Arapaho Phase II ~~III~~ Meeting

ALIGNMENT STUDY CONCLUSIONS AND RECOMENDATIONS ARAPAHO ROAD EXTENSION

Town of Addison, Texas

Dan - Some comments - Jim
12-21-98

ALTERNATE 5 OVERPASS WITHOUT RAMPS

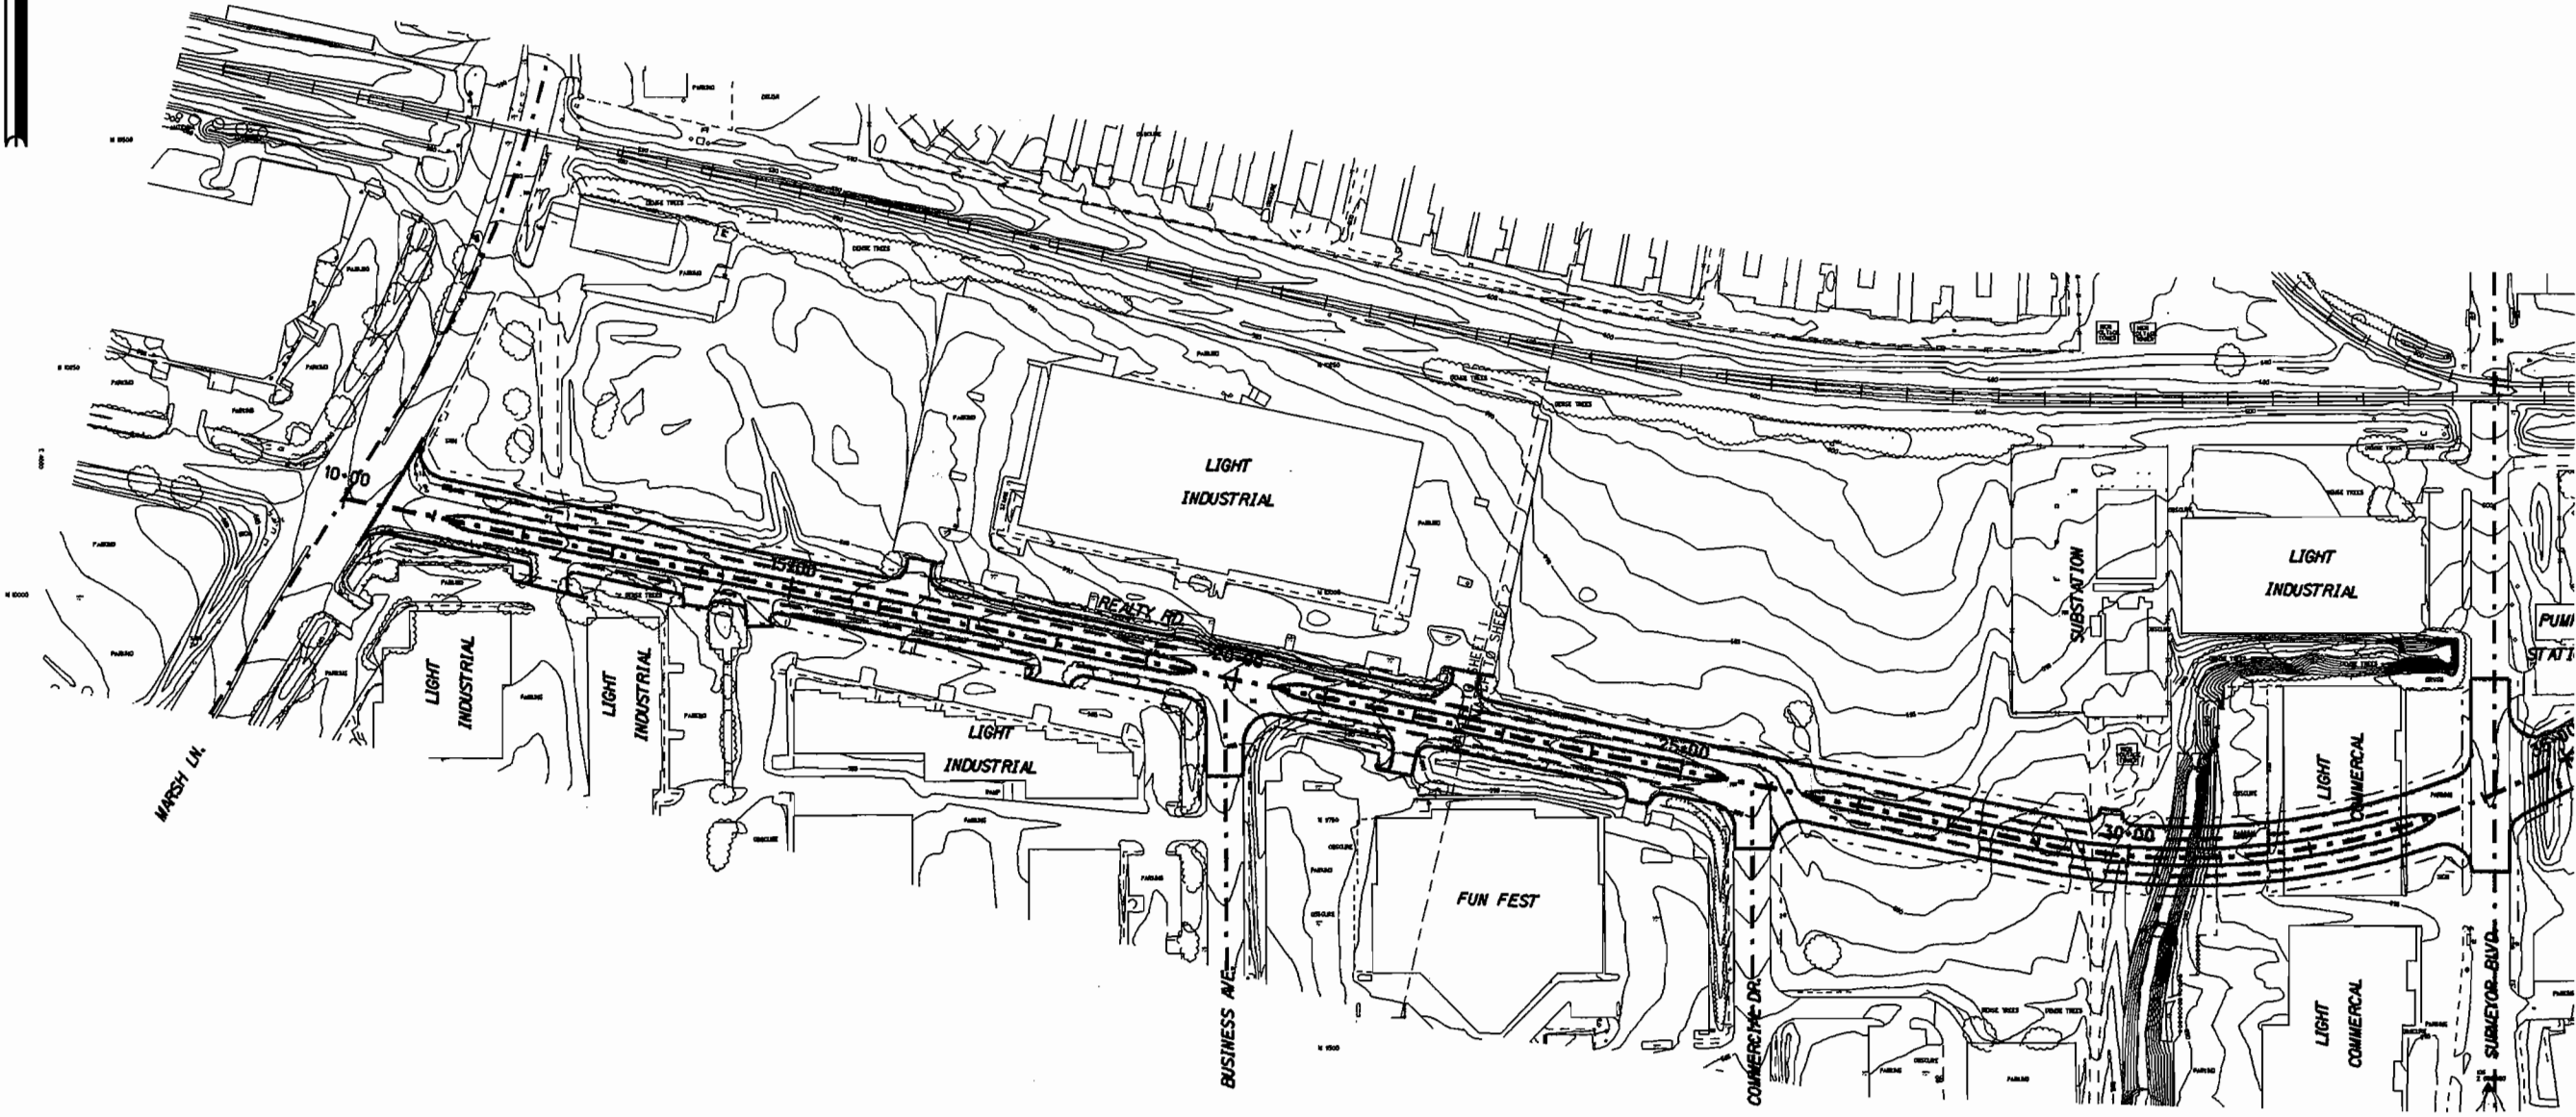
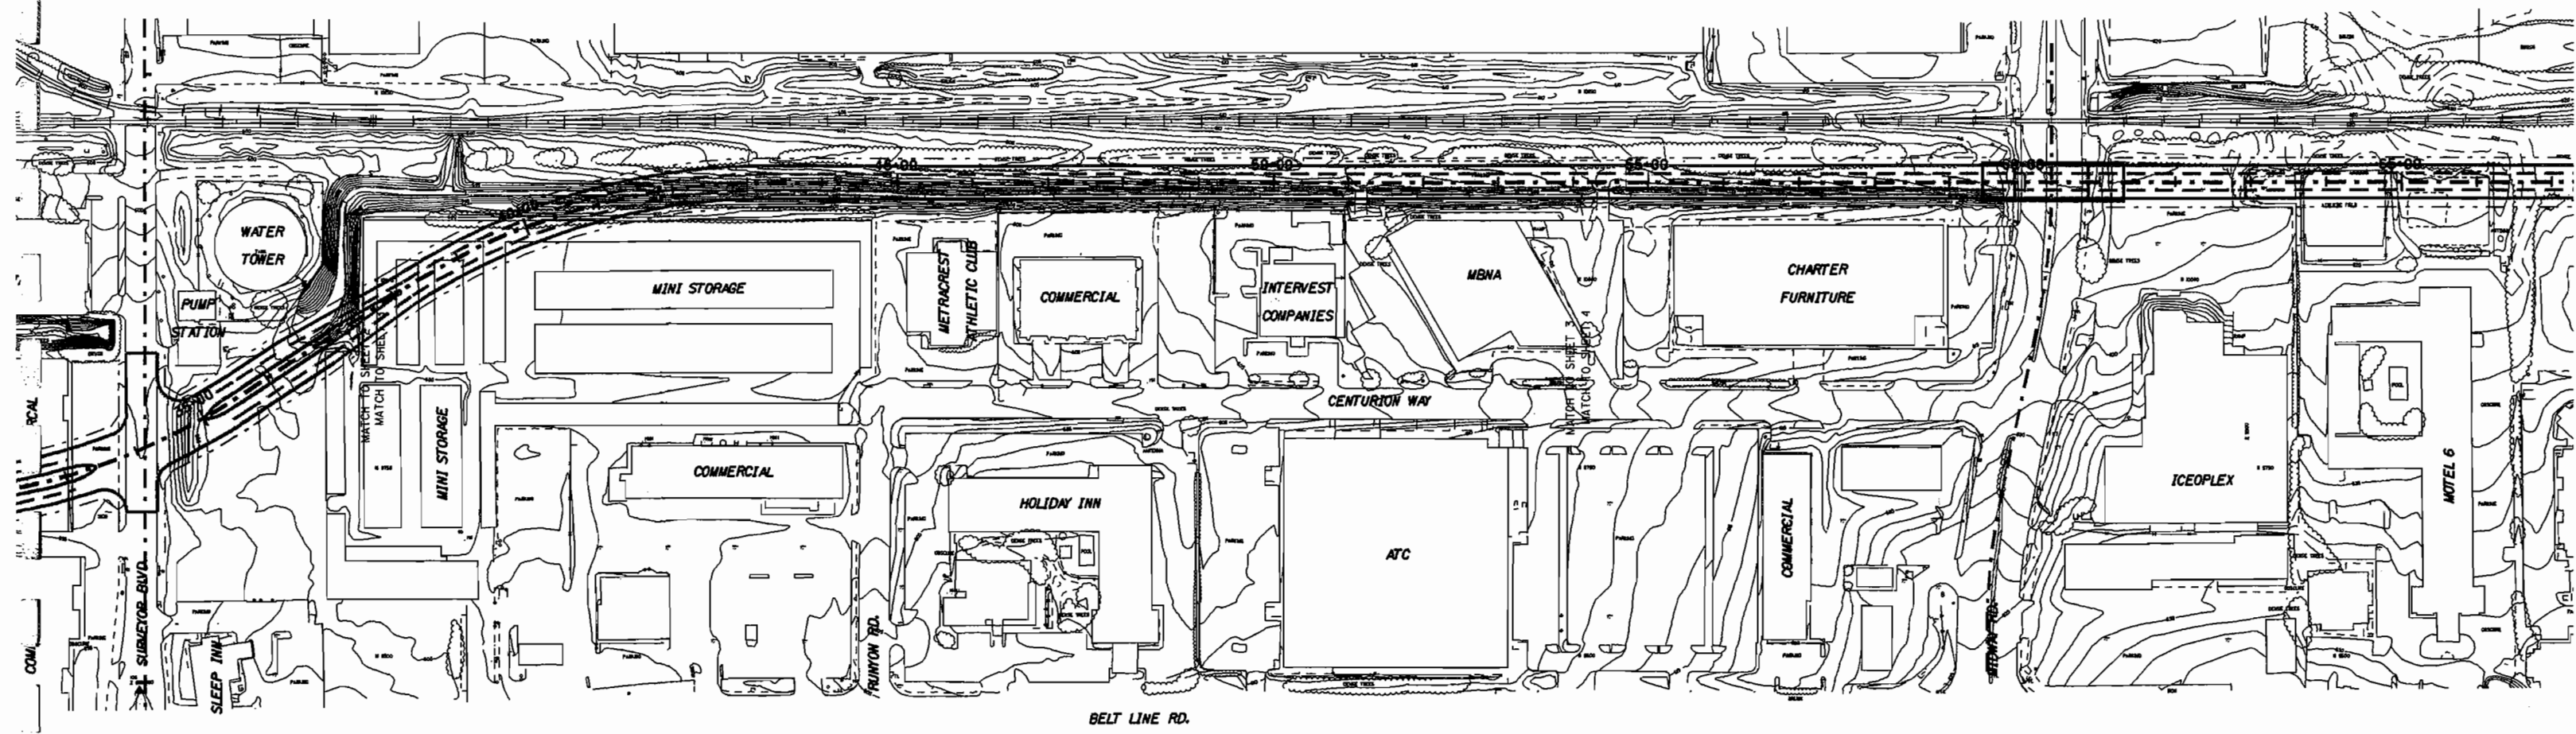
- **GEOMETRY** - The alignment would be on straight tangent, parallel to tracks.
- **SAFETY** - No significant safety issues foreseen.
- **RIGHT-OF-WAY** - The alternative would not require the acquisition of the Charter Furniture building if roadway clearance of only 9 feet would be acceptable to the Town of Addison and Property Owner.
- **CONSTRUCTIBILITY** - Same as Alternate 1, except retaining walls would require relocation of Dallas Water Utilities (DWU) 60-inch water line.
- **COST** - The cost of this alternative is essentially the same as underpass alternative, Alternate 1.

Of the three overpass alternatives analyzed, Alternative 5 pushes the south overpass wall within 9 feet of the Charter Furniture building without a sidewalk for emergency access on the overpass. In addition, it would require DWU to accept 15 feet for maintenance of their 60-inch water line. This is their normal easement width for a much smaller service line.
